**SUBMISSION TO THE DEPARTMENT OF PLANNING AND INFRASTRUCTURE ON THE PROPOSED
NORTH WEST RAIL LINK (NWRL)**

Application Number: SSI-5100

Whilst I support in principle the construction of the NWRL to provide much needed public transport to the rapidly growing housing areas of north west Sydney and to reduce the pollution and congestion associated with road transport, I object to the following regarding the Cheltenham Intermediate Services Facility.

Figure 6.11 Cheltenham Services Facility light vehicle access and egress

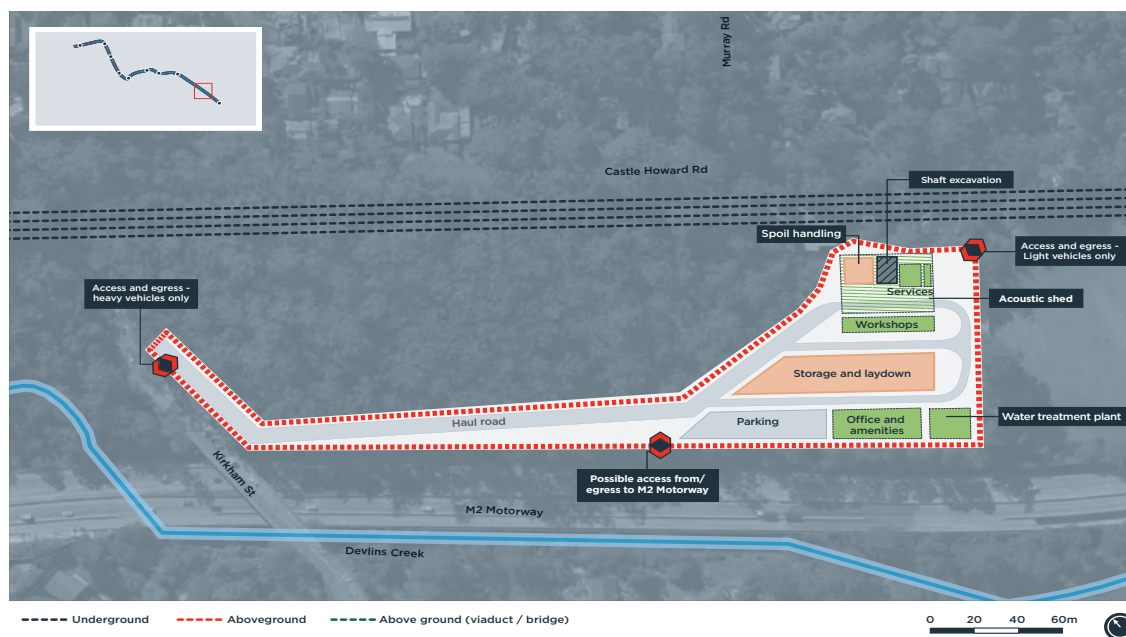
1. The option to construct a new two lane paved road through the Castle Howard Conservation Reserve to Kirkham Street (or Castle Howard Road) near the bridge over the M2 to allow trucks to remove spoil during construction and light vehicle access during operation of the facility will permanently destroy valuable Blackbutt Gully forest.

5. Should the roadway be built, the local streets (Kirkham Street, Castle Howard Road, Murray Farm Road and the bridge over the M2) are narrow, winding and congested and would not be suitable for trucks and, in the event of an emergency, large numbers of emergency vehicles.

6. There are no traffic lights at the corner of Kirkham Street and Beecroft Road. This is a dangerous intersection for traffic and pedestrians and would not be suitable for trucks and emergency vehicles.

I therefore ask that you adopt the alternative option of access to the site for construction and emergency vehicles be via new on and off ramps from the M2 motorway. The current widening and reinstatement of the breakdown lane should allow this access. It is the only practical way to move trucks in and out of the site. In the event of an emergency, many emergency vehicles would need quick access to the site from areas outside Beecroft and Cheltenham as it only has one fire engine.
